Notice of Exhibition - Kariong Sand and Soil Supplies Facility (SSD-8660)

Fire & Rescue NSW (FRNSW) acknowledge the receipt of your email on the 26th August 2020, requesting input into the amended Environmental Impact Statement (EIS) and a Response to Submissions (RtS) Report for the Kariong Sand and Soil Supplies Facility (SSD-8660).

FIRE SERVICE REQUIREMENTS	
FLOOR AREA OF BUILDING	2,206m ²
CLASS OF BUILDING	8 & 5
OPEN YARDS	<9,000m ²
FHR REQUIRED	YES
FH COVERAGE REQUIRED	YES (EXTERNAL)
BUILDING SPRINKLERED	NO
FLOW REQUIRED	20L/s
FLOW REQUIRED AT BOOSTER	20L/s
PRESSURE REQUIRED	250 kPa

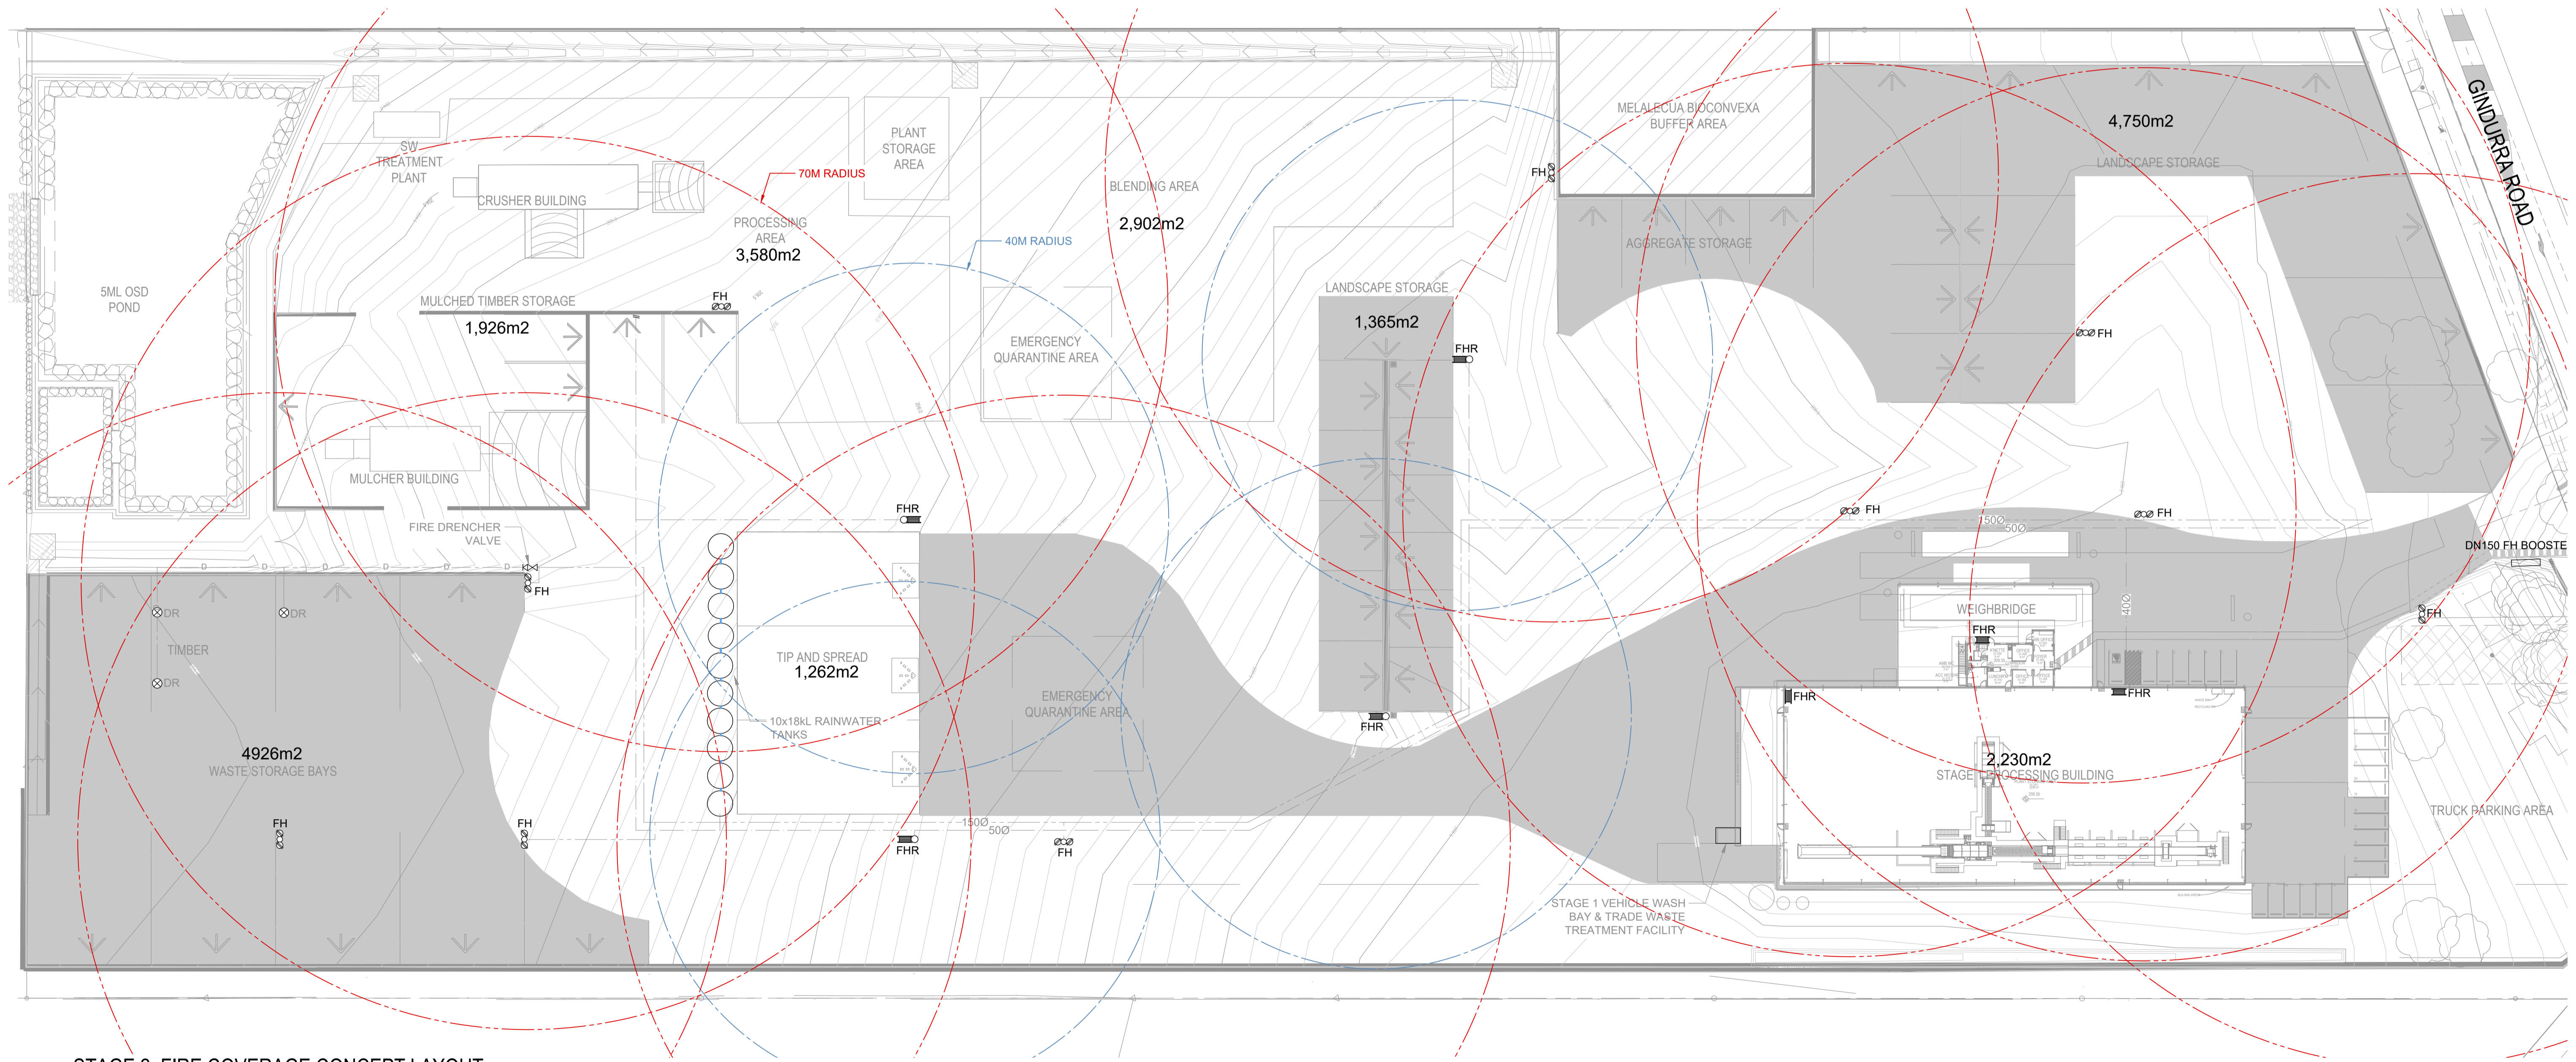
- The fire safety study report should detail the layout of the proposed automatic sprinkler system for the site.
- The fire safety study report should provide evidence of the hydraulic calculations for the *sprinkler* and *hydrant* systems.

- A compliant fire hydrant system for the *entire* site including the following items; pressure, flow rates, layout, coverage, design, accessibility, connection points and isolation valves, as per *AS 2419.1 – 2005 standard*.
